September 15, 2020

JN 16448-1

Subject: **Review of Plans and Statement of Risk Letter**
Proposed Single-Family Residence
9785 Southeast 41st Street
Mercer Island, Washington

A. TEMPORARY EXCAVATION PLAN

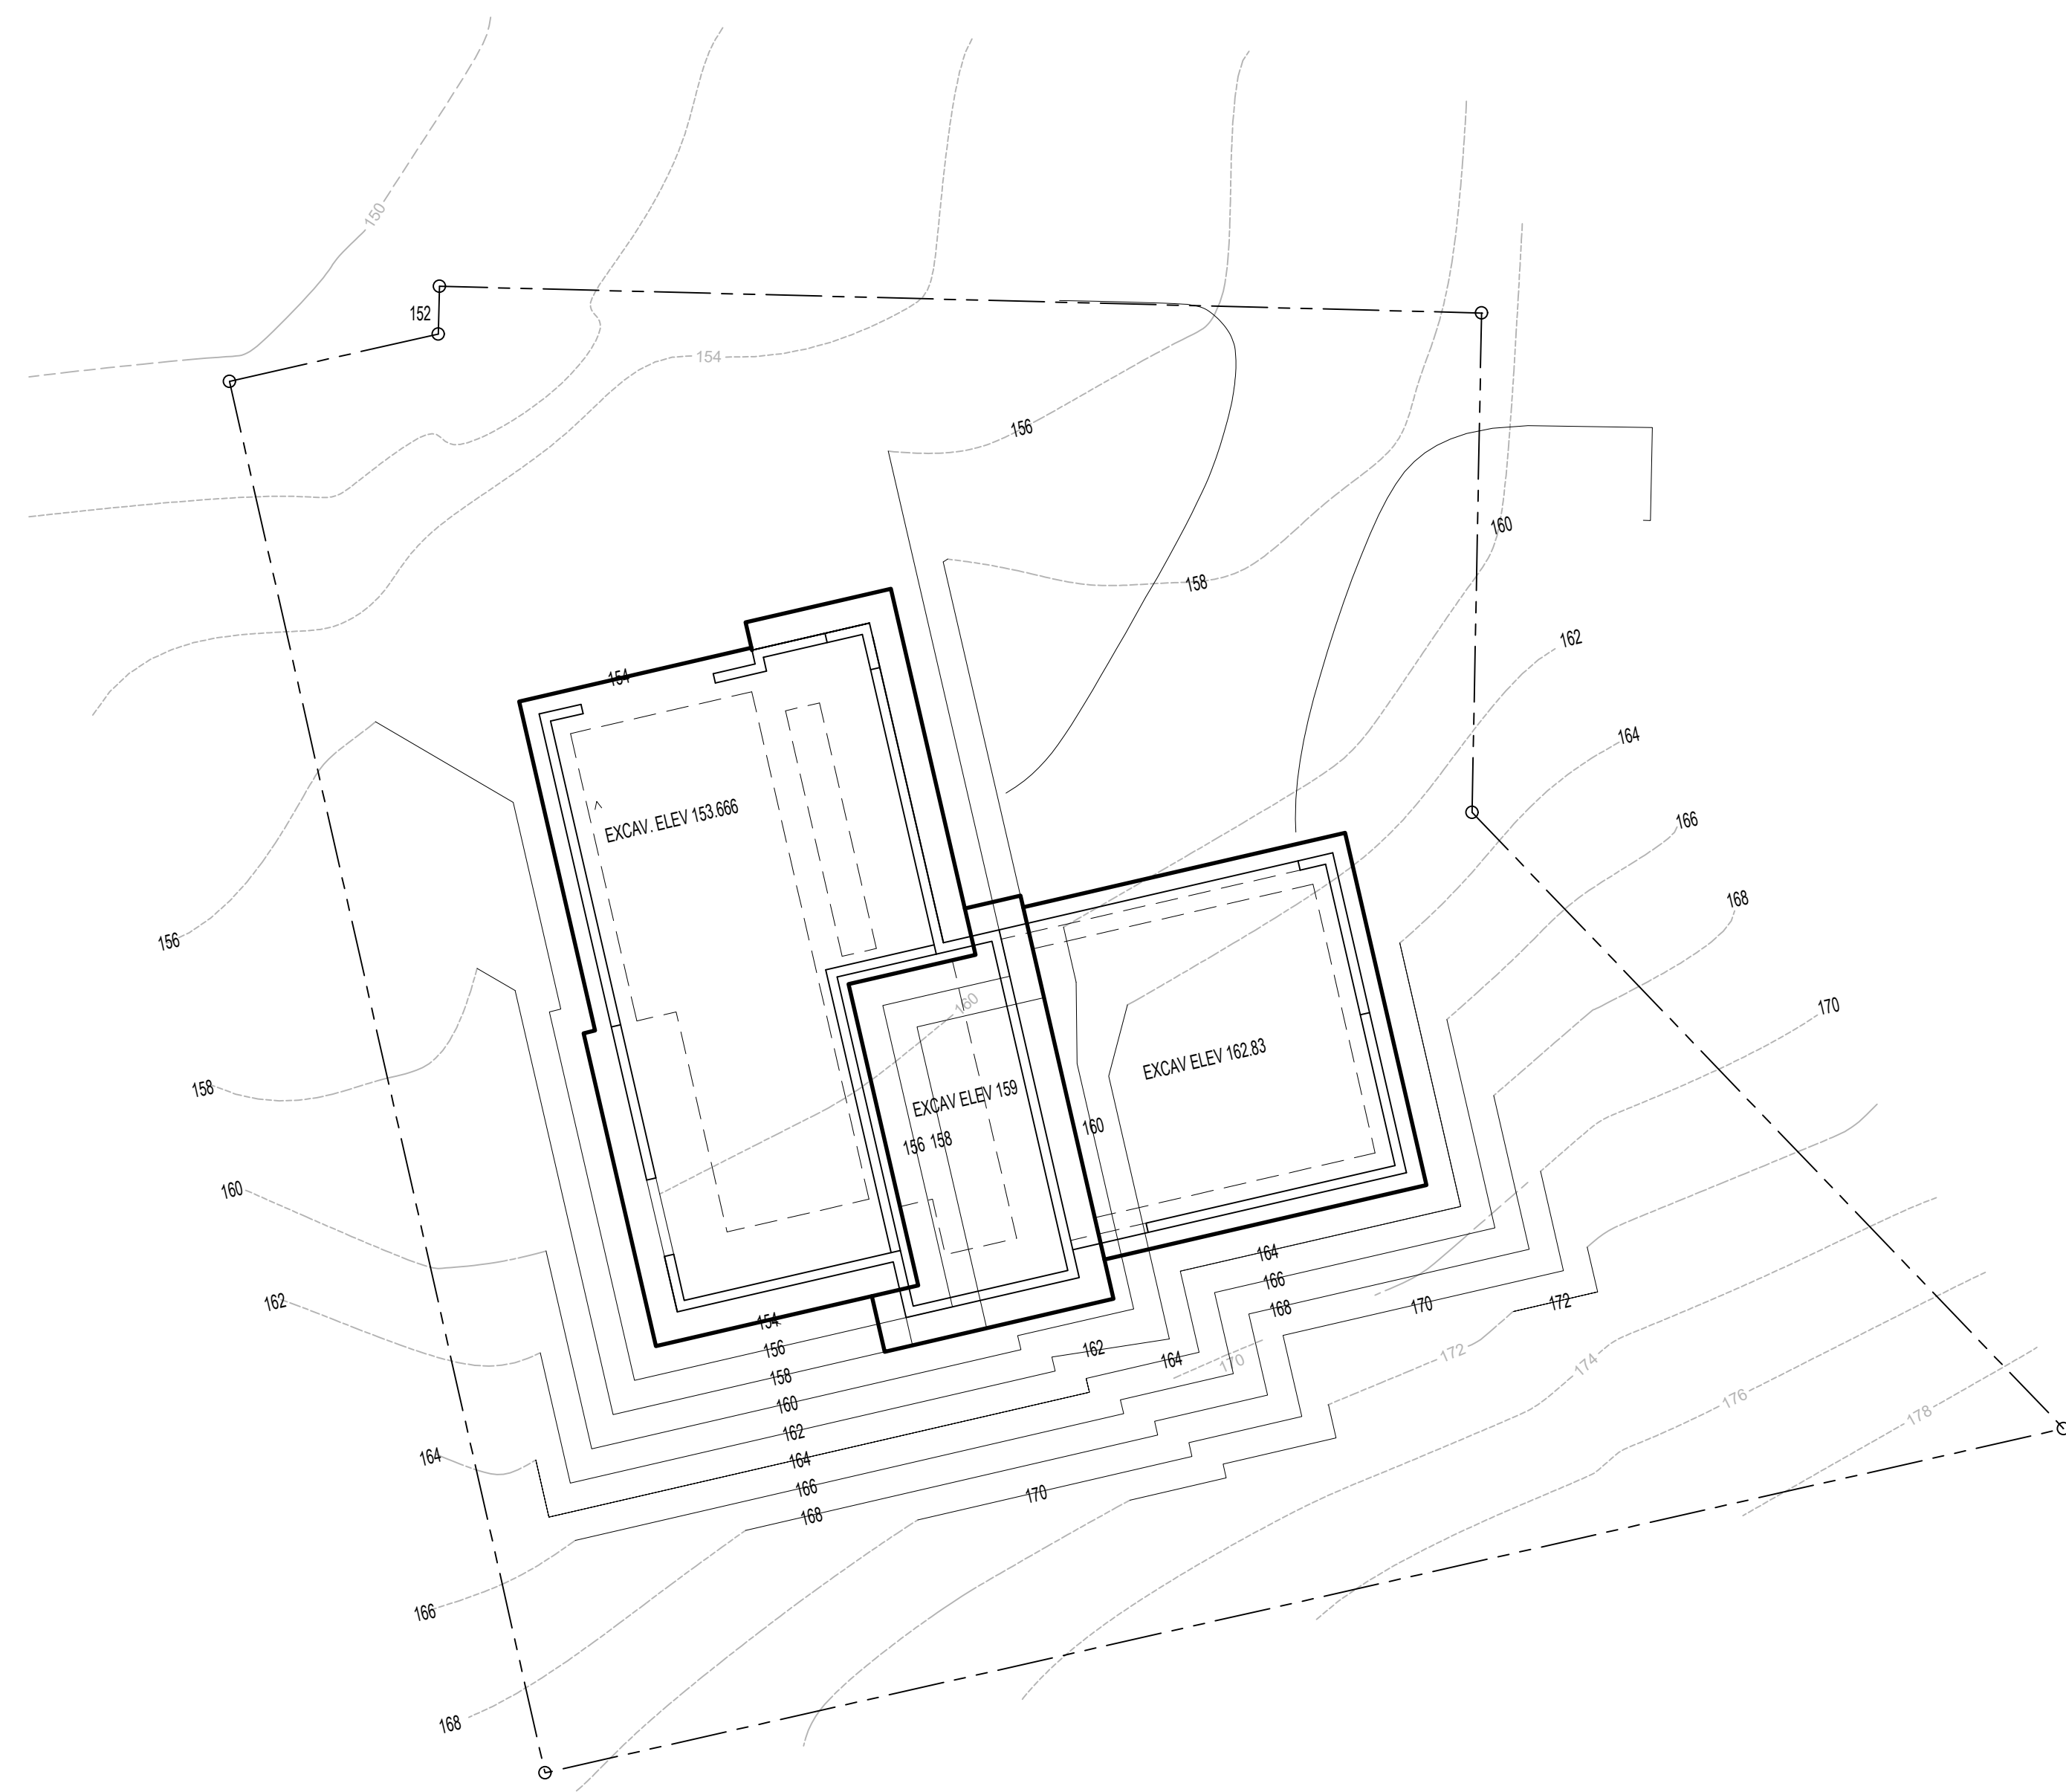
Included in the plans, as requested by Mercer Island review, was an excavation plan as well as information regarding a wall on the southern side of the residence patio. The excavation plans indicate that the excavation will adequately be kept within to property lines. The wall information indicates that a concrete, cast-in-place wall with a footing is proposed on the southern side of the patio. Both of these items are very suitable within the plans in our opinion
